Permit Inspections Harnett County

Permit Number: BRES2108-0041

Description: **covert ext scr to living space, small porch**

Site Address: **89 GILLIS CT**

sheet no.
S1 of **S1**
 plan no.
2202-11

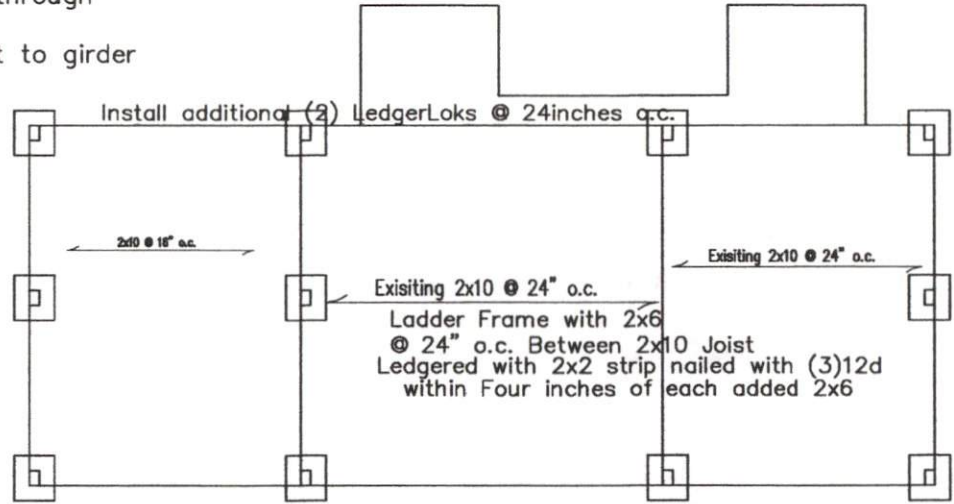
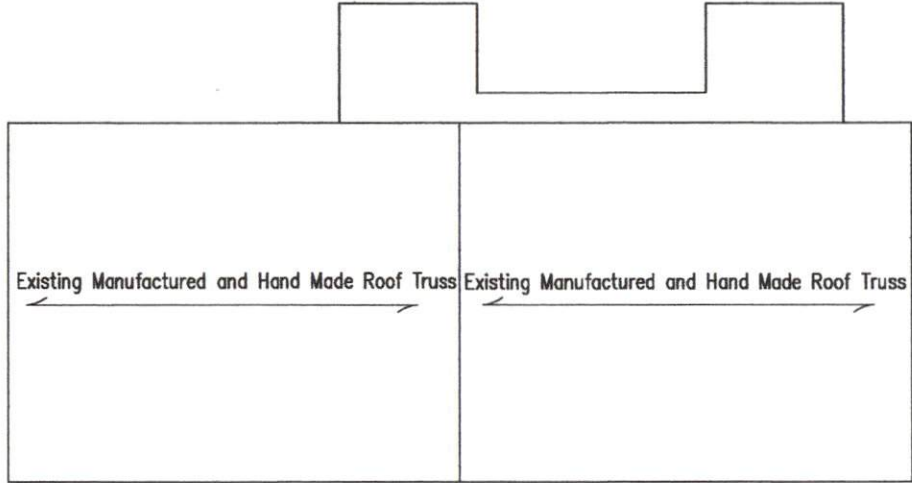
SEQ ID	SCHEDULED DATE	COMPLETED DATE	TYPE	INSPECTOR	RESULT	REMARKS
			FOUNDATION	Deen Taylor		
Notes:						
			MONO SLAB	Deen Taylor		
Notes:						
			SLAB	Deen Taylor		
Notes:						
			UNDER SLAB TRADES	Deen Taylor		
Notes:						
			OPEN FLOOR	Deen Taylor		
Notes: Engineered for open post support. See plan						
			ROUGH IN REINSPECT	Deen Taylor		
Notes:						
	3/2/2022	3/2/2022	FOOTING	Deen Taylor	APPROVED	
Notes:						
	5/10/2022	5/11/2022	FOOTING	Deen Taylor	APPROVED	
Notes: cus request another inspection before pouring concrete						
	8/23/2022	8/23/2022	ROUGH IN	Deen Taylor	DISAPPROVED	
Notes: Window within 24 inches of door upstairs must be tempered. Top of gate must be 36 inches from walking service for upstairs deck.

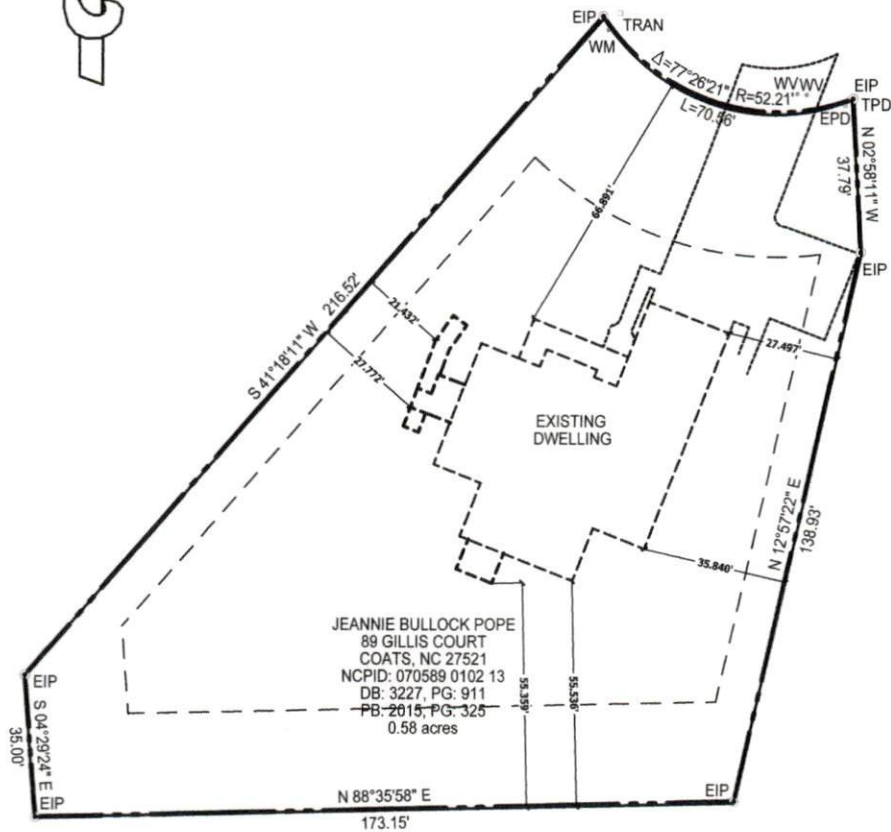
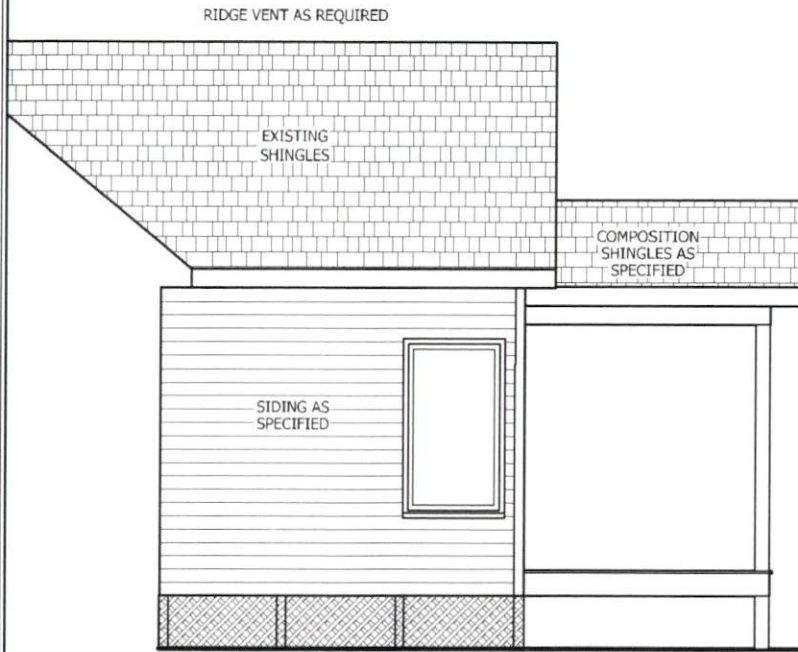
Proposed Addition is on top of existing septic system. Can not approve, sent builder to SS to have new system and repair design.
